DATE:  
FEB 5, 2022  
PROJECT NO.  
100.065  
SHEET NUMBER  
**C9.2**  
TOTAL SHEETS: XX

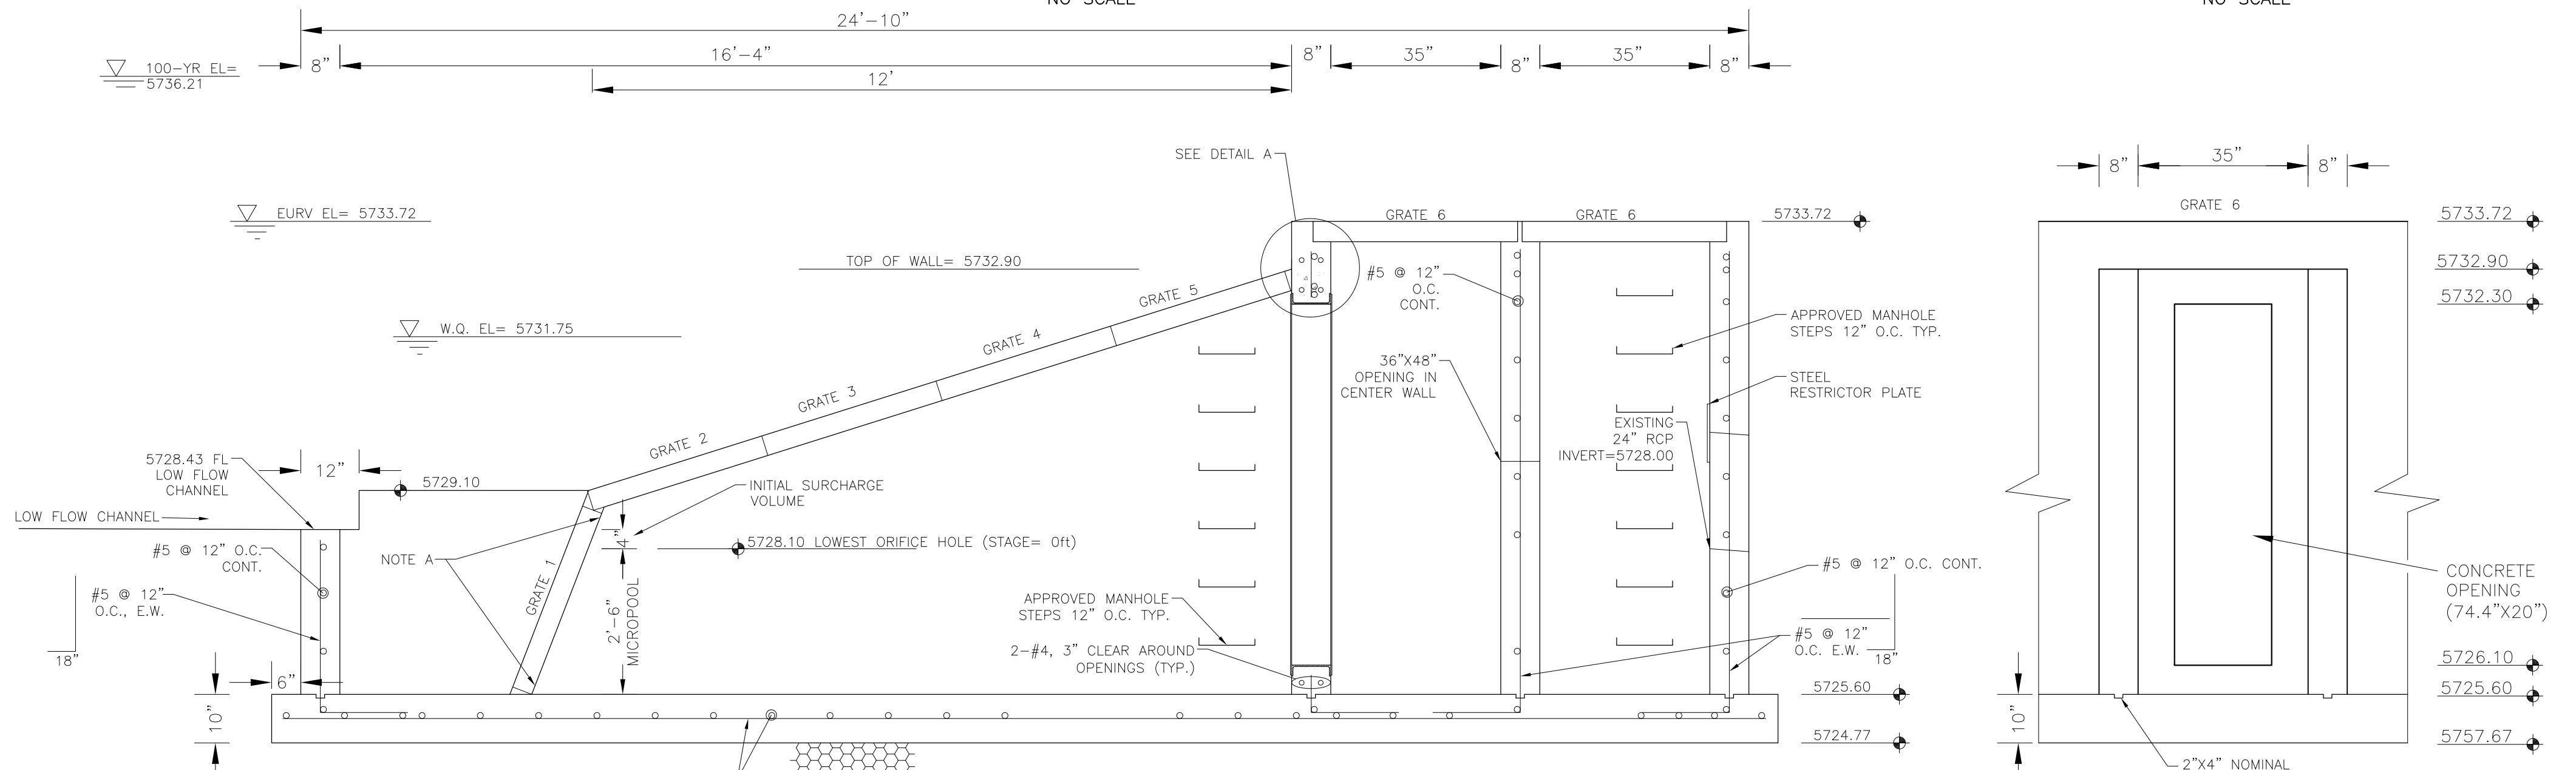
| does not match what is shown on Sht C9.2 of GEC Plans. Revise to remove discrepancy. | | |

| NOTCH UPDATED | | |
